From: pete jackson [REDACTED]
Sent: 18 March 2020 11:51
To: Planning.Responses <Planning.Responses@arun.gov.uk>
Subject: Fwd: BN/66/19/PL - Objection

From: Peter Jackson [REDACTED]
Date: 17 March 2020 at 14:24:07 GMT
To: neil.crowther@arun.gov.uk
Cc: maria.tomalova@arun.gov.uk
Subject: BN/66/19/PL - Objection

I wish to object to the latest planning application above:-

Drainage Strategy Drawing

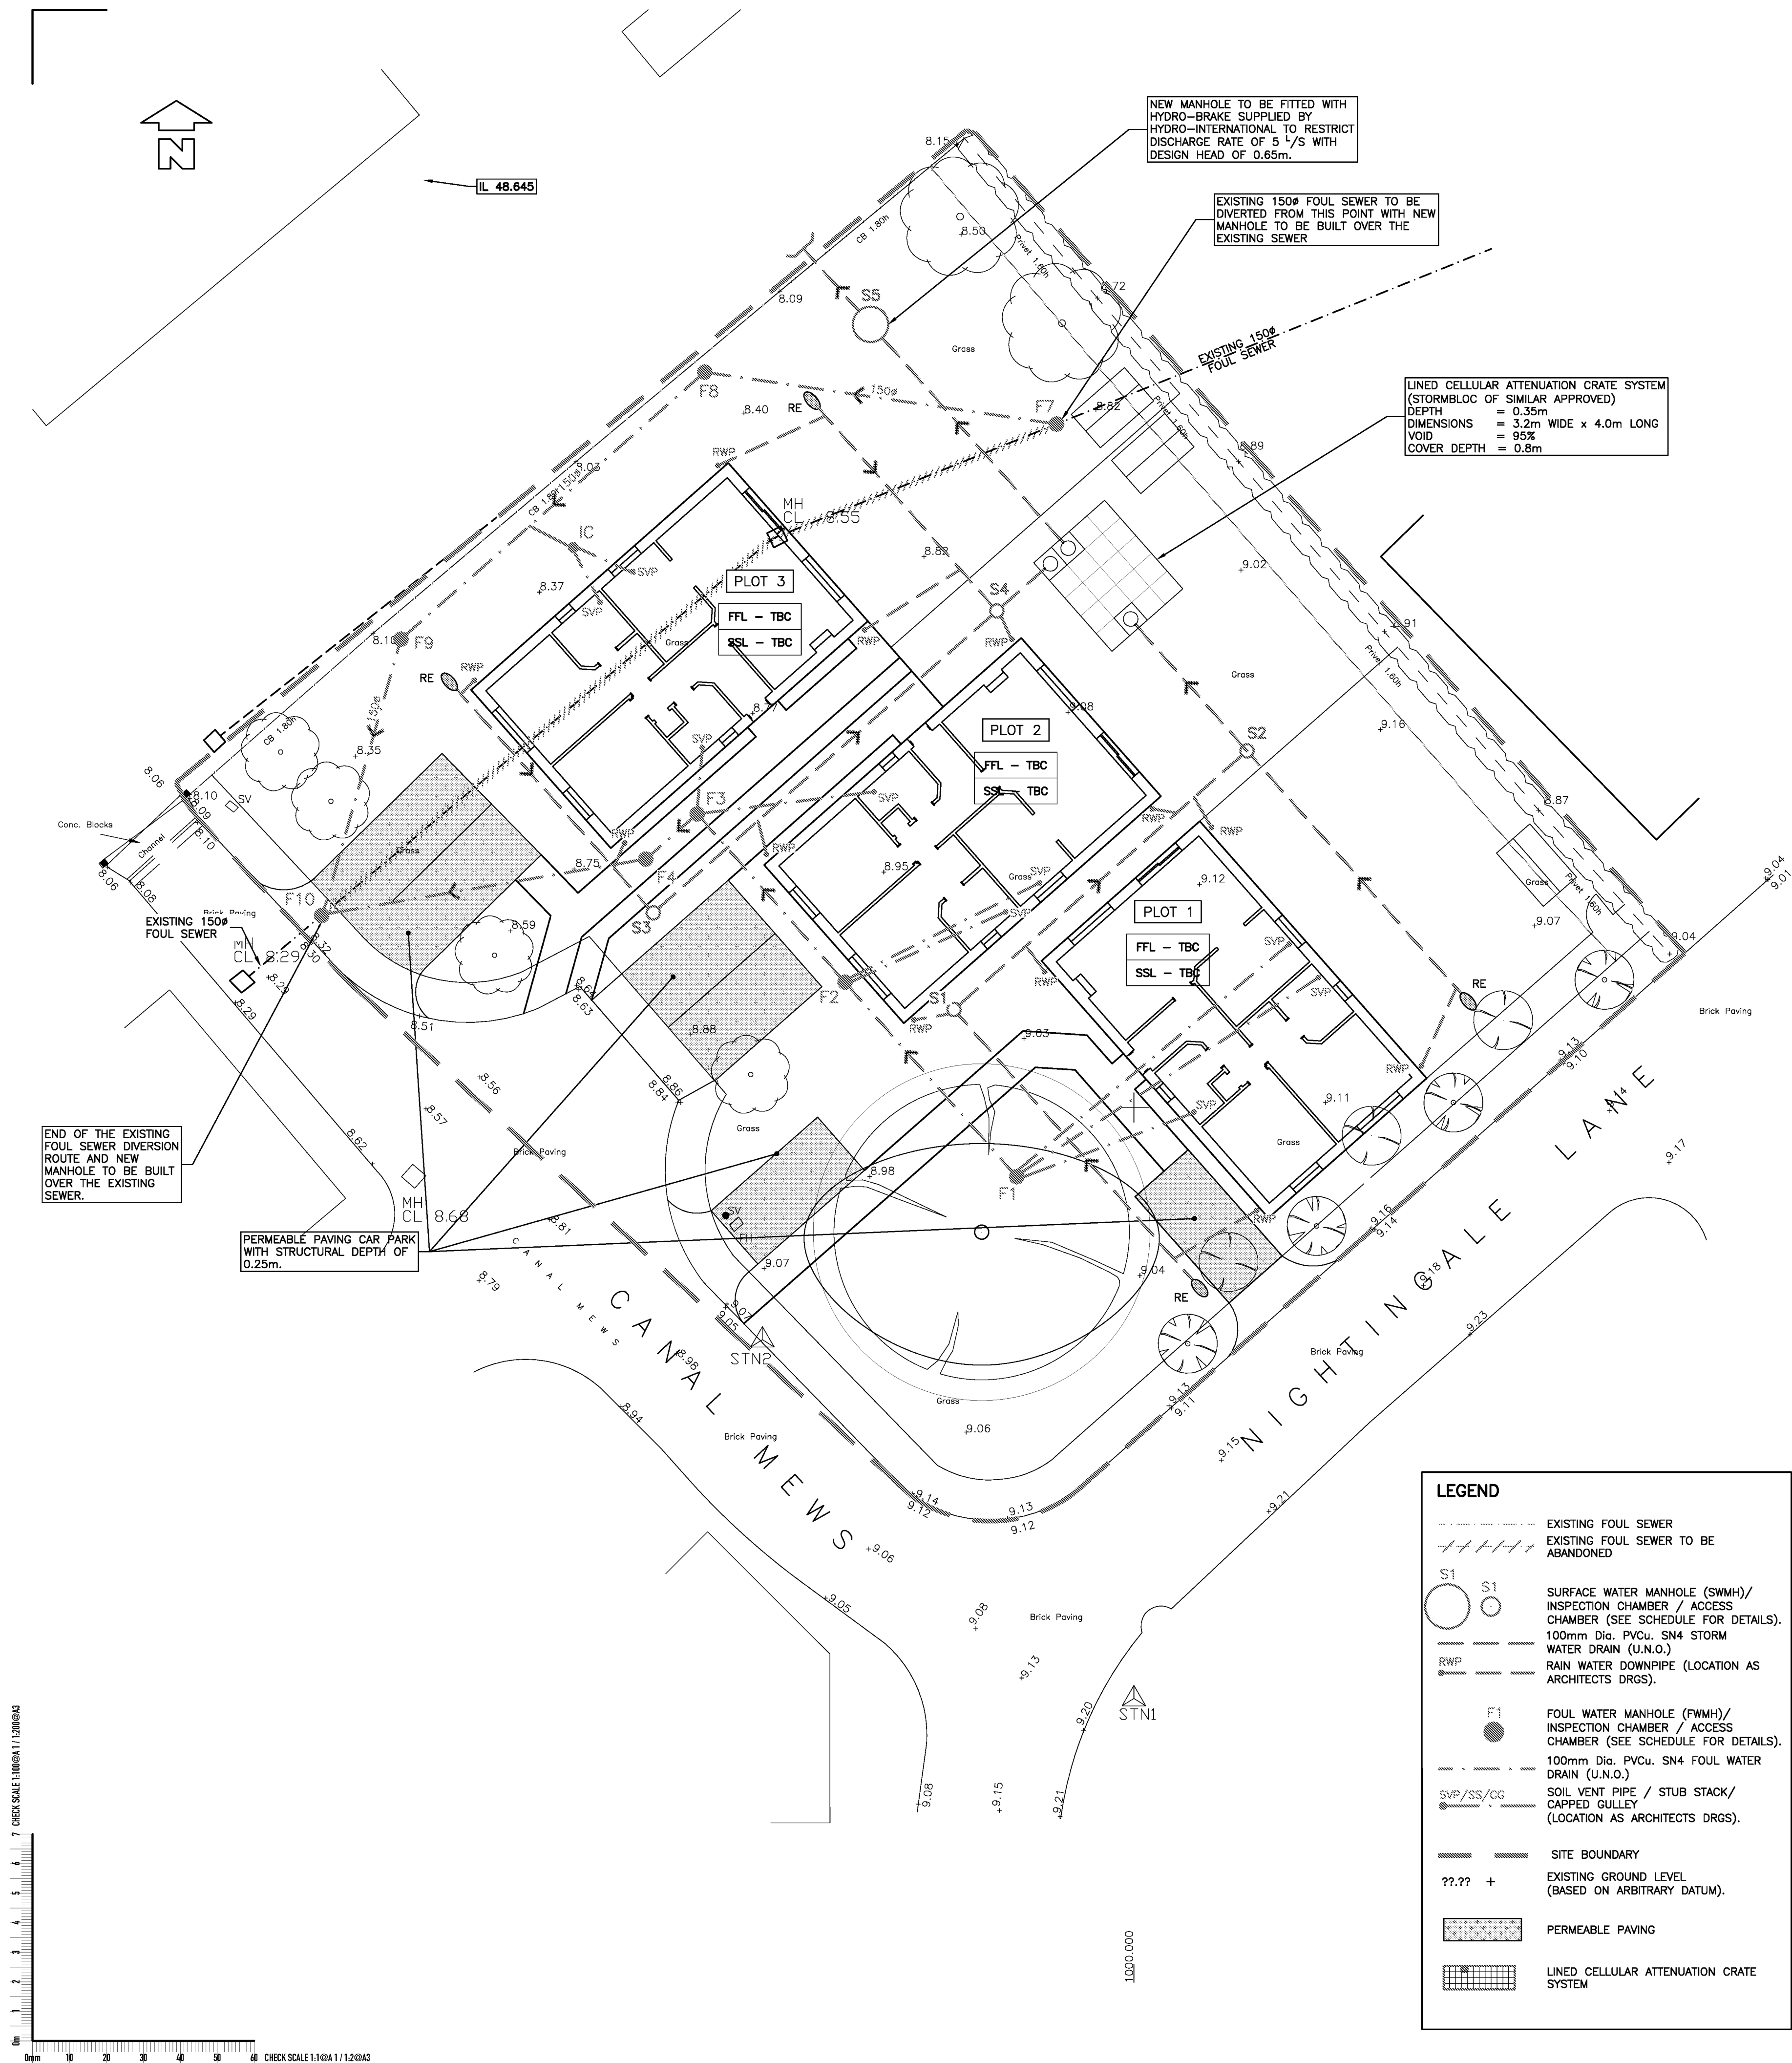
1a. The proposed planning states that our private sewers (as validated by Southern Water) would require re-siting and tapping into by another developer, all without prior agreement and with no appropriate consideration regarding any contribution towards the private maintenance, repair, liability and future unforeseen costs appertaining - STATUS UNRESOLVED.

1b. Liability - who is responsible for any issues/problems during and after the proposed alterations to our private sewage system? Equal consideration should be given to this, which has a well documented history of backup and blockage within the homes on Arun Place and already at

2. Surface water drainage - Within Arun Place there is a well documented surface water drainage issue, which has been previously highlighted. Our home has suffered vast areas of flooding to the gardens which will undoubtedly incur imminent costs in professional horticultural input in an effort to resolve. The drainage issue can also be seen within the proposed development area (see attached image - with pooling and evident beneath ground water bubbling) . This is a serious issue for future plans which cannot be ignored - STATUS UNRESOLVED.
